Application for Legal Development Certificate ref. FP/47/26/CLP

Project: The Watch House
Old Coastguards
Felpham
PO22 7BJ
Client: Mrs Mountain
Drawing Title: Proposed Elevations & Floor Plan

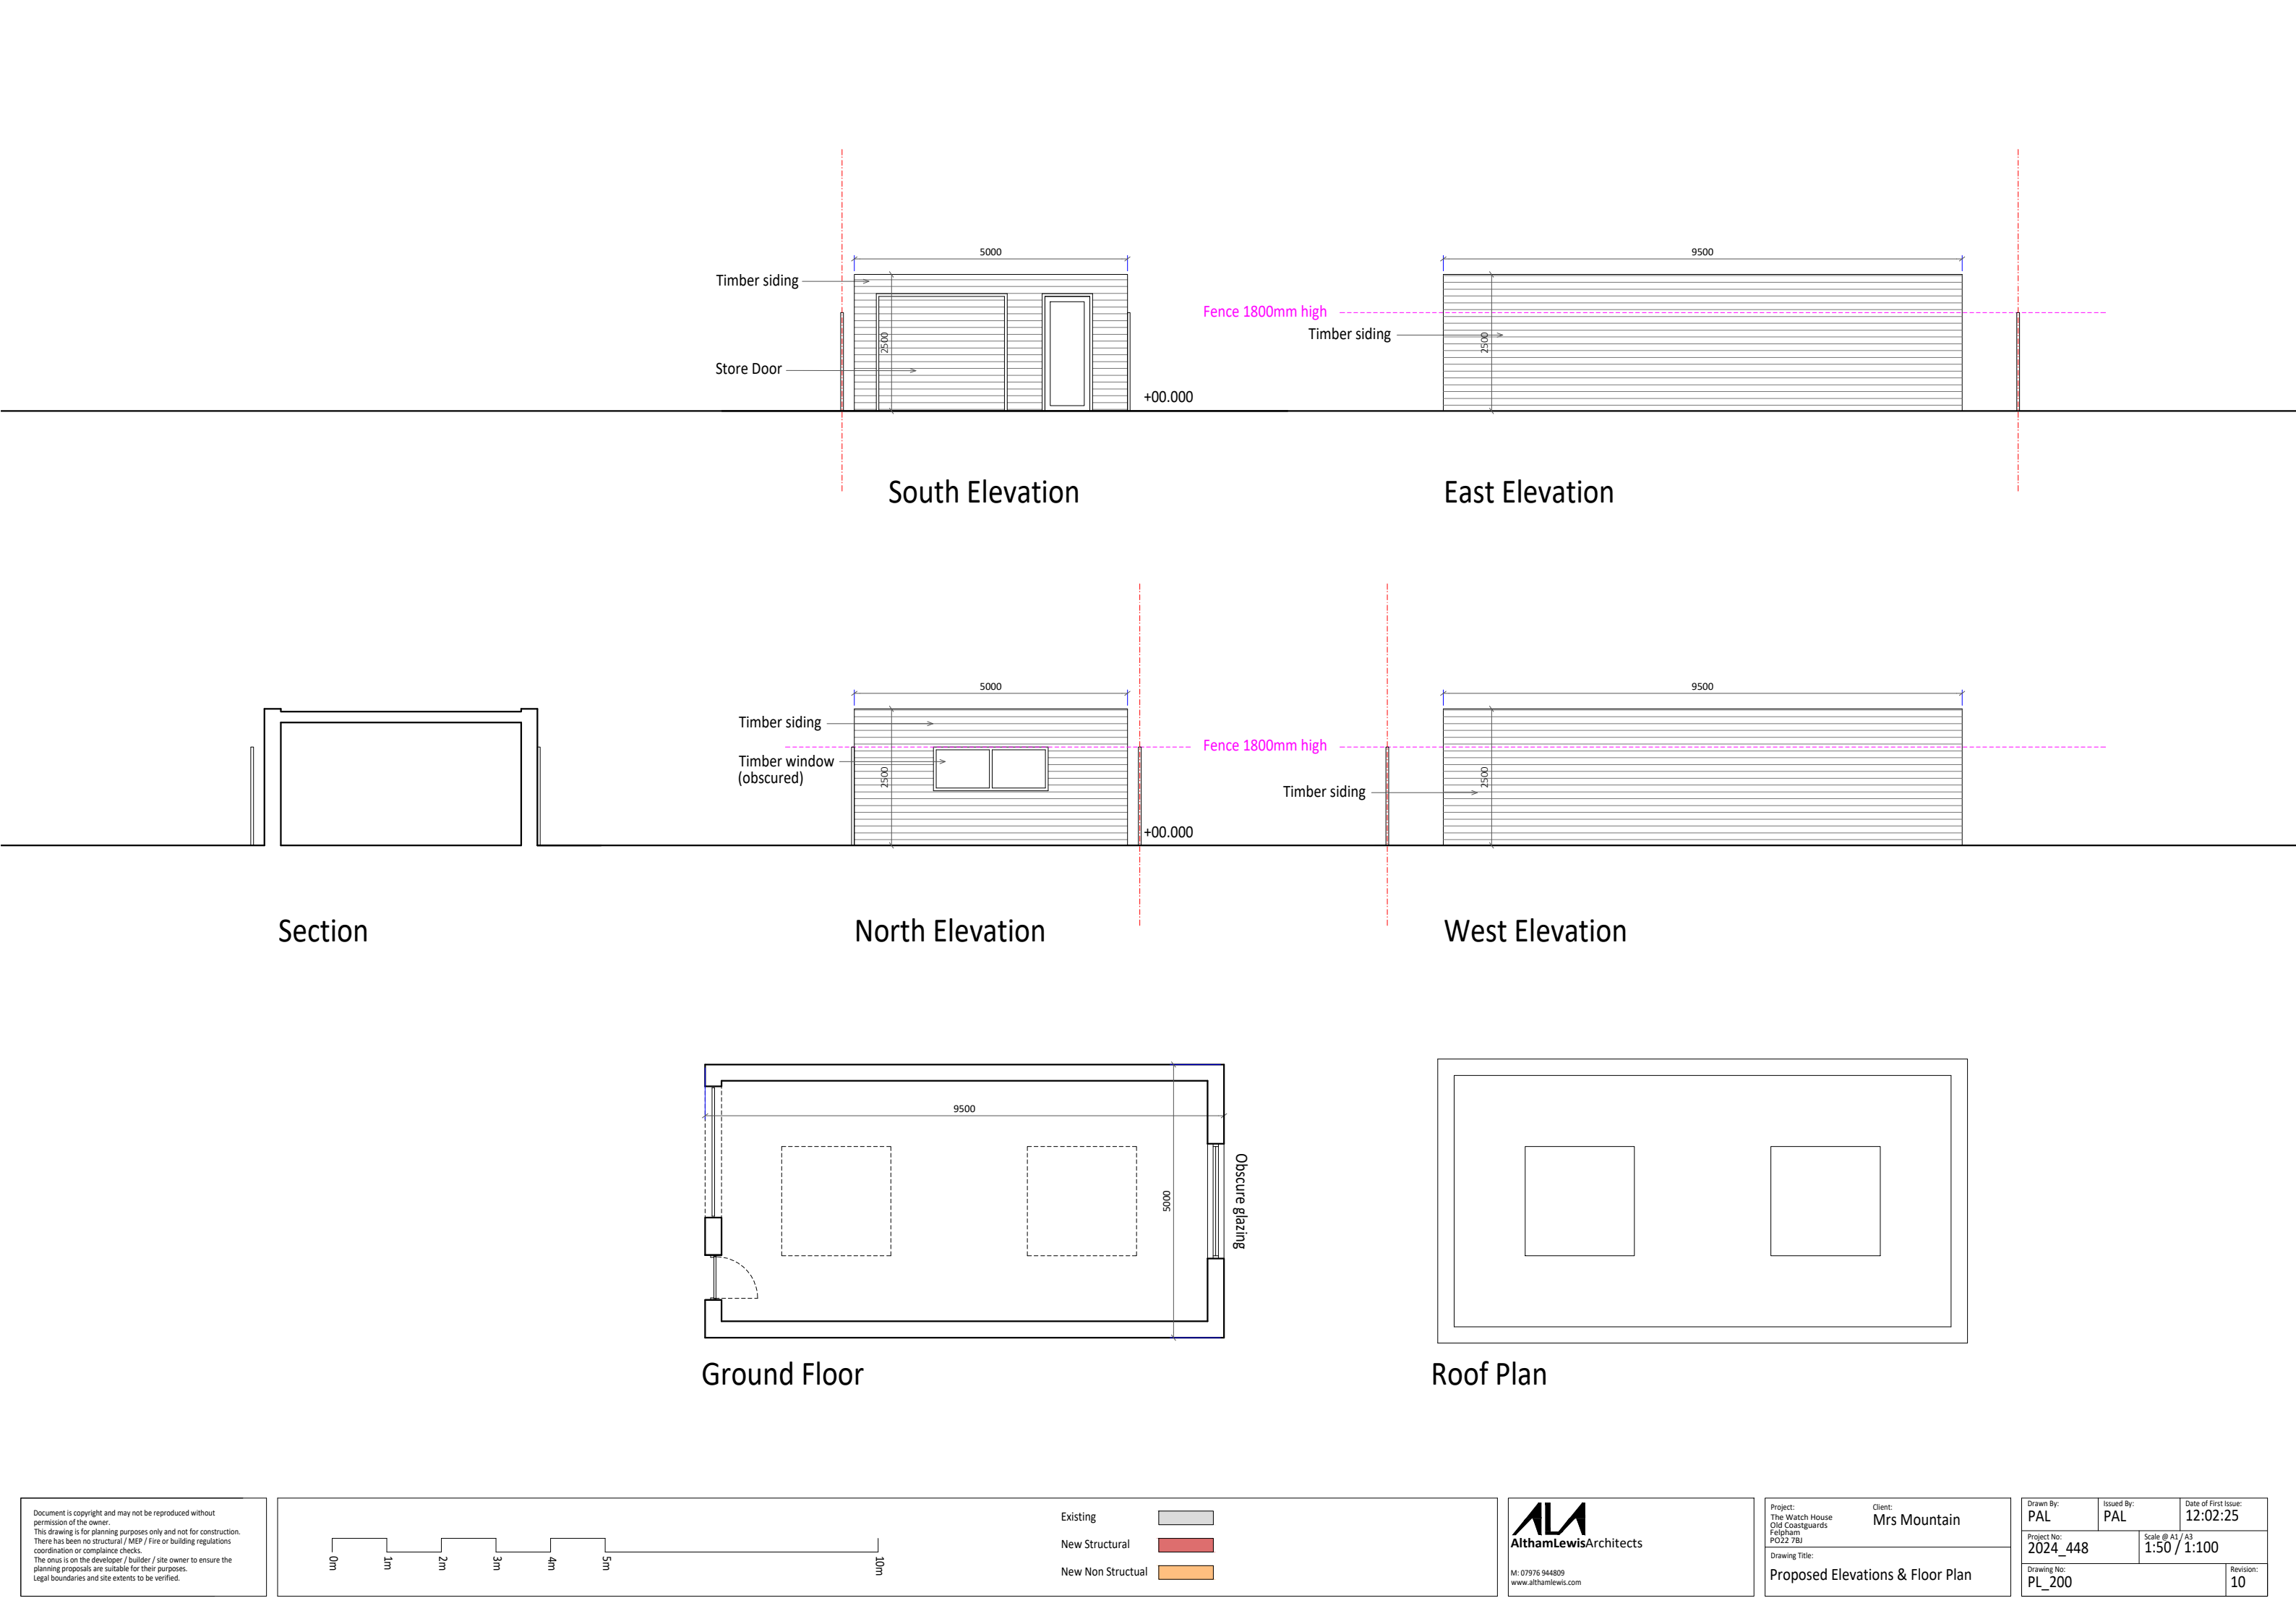
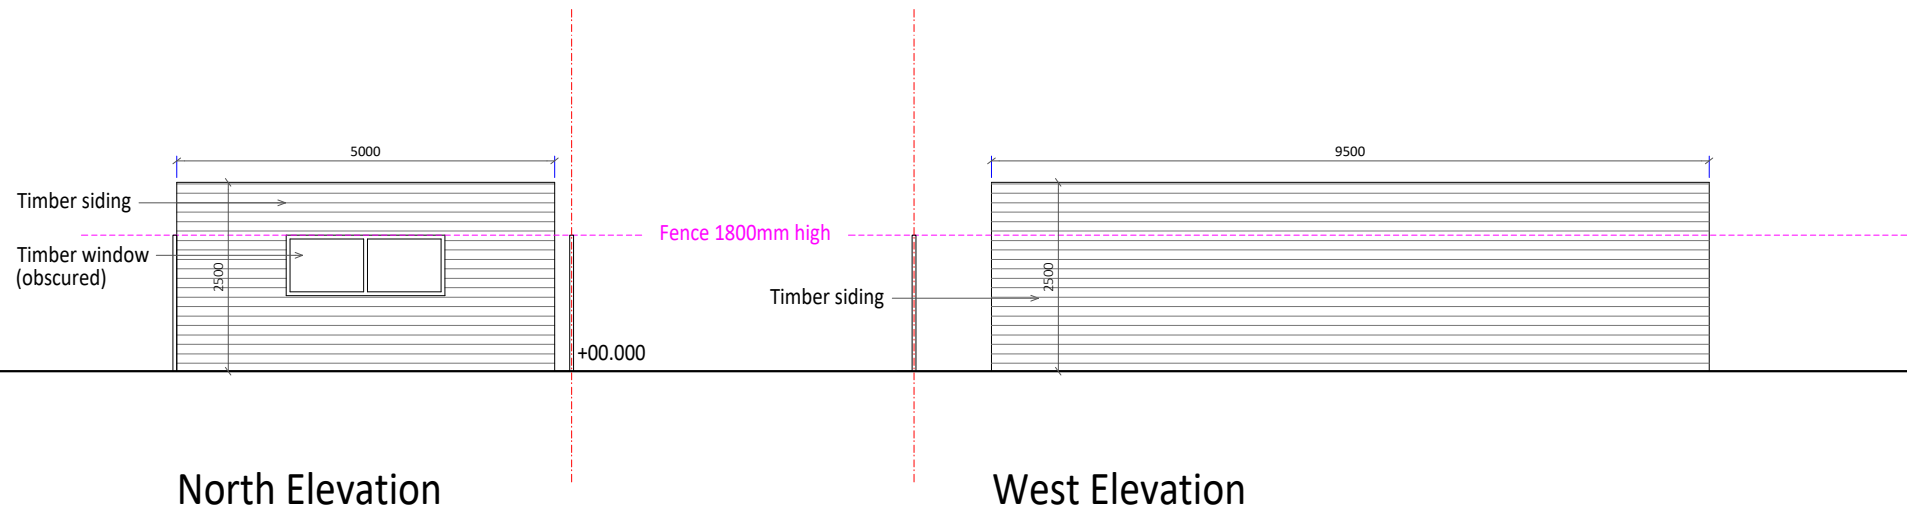
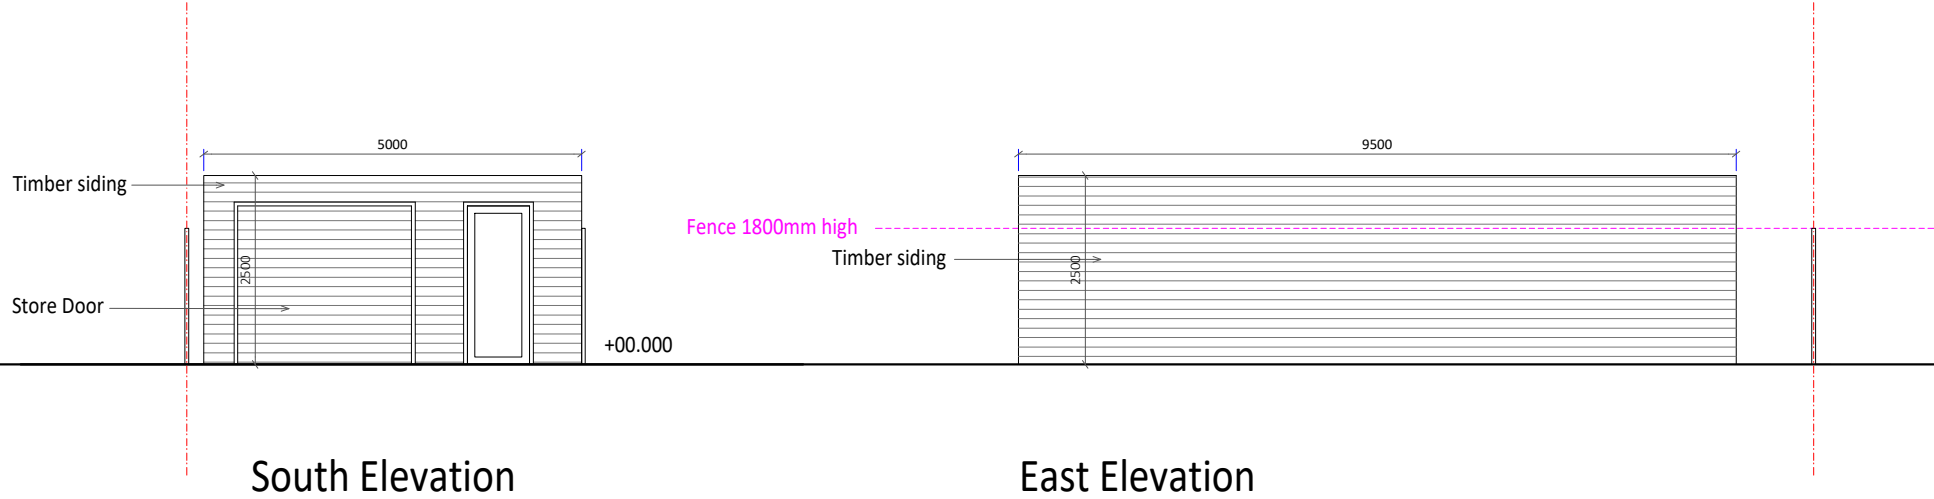
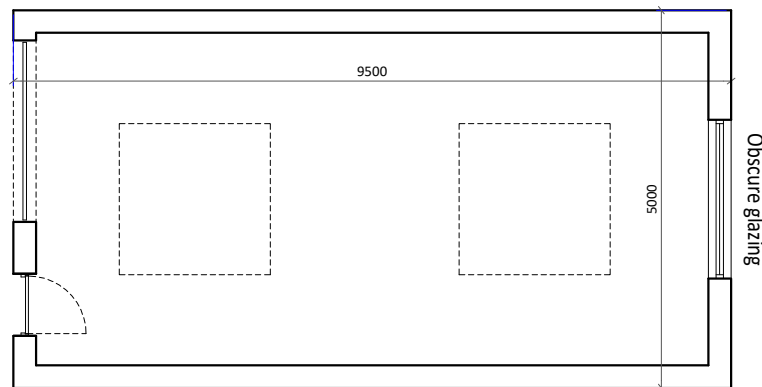
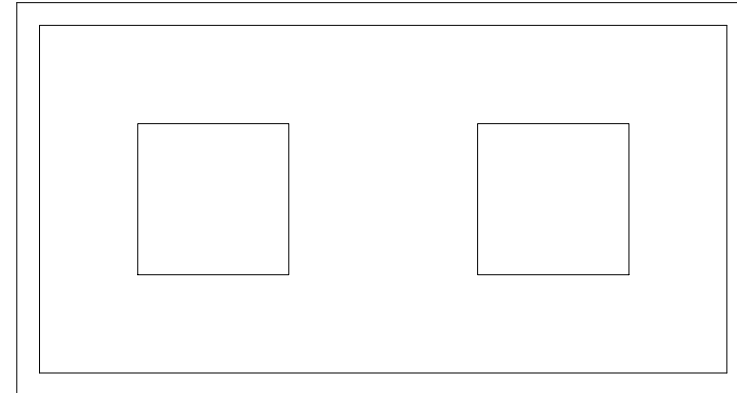
As in FP/134/25HH, the statement says that the proposed development is "slightly larger than" the existing. This is incorrect and disingenuous. The external footprint of the proposed structure is 47.5 sqm. This is 2.96 times that of the existing structure.

As in FP/134/25HH, the proposal reaches the eastern and western boundaries. The eastern boundary abuts a path and the western boundary abuts another property.

The Arun Design Guide SPD 2024 states that the side and rear of two neighbouring properties must be at least 14m apart. The proposed development would be considerably closer than this to Eaves and Nos. 1 and 2 Coastguards Cottages. The edge of the proposed building would be 1m, 5m and 7m from our garden, conservatory and rear wall respectively, and 2m from The Eaves.

The paved area in front of the existing structure should not be counted as "space around the property" since this is an access route for other properties. The two existing garden spaces total approximately 79sqm and the proposal represents 60% of this area.

The plan refers to a “multi-purpose room”, the use of which is notably undefined. The statement says that the structure will be used as a “storage area and incidental space”. This, as with important elements in FP/134/25/HH, is contrived. The footprint of The Watch House, to which the new building is proposed as an annexe, is approximately 35sqm , and the proposed structure is 35% larger. There are very few reasons for creating storage space of this size in relation to a house: the only likely purpose in this case is for later conversion to habitable space, which we know from both previous applications is the aim of the applicant.
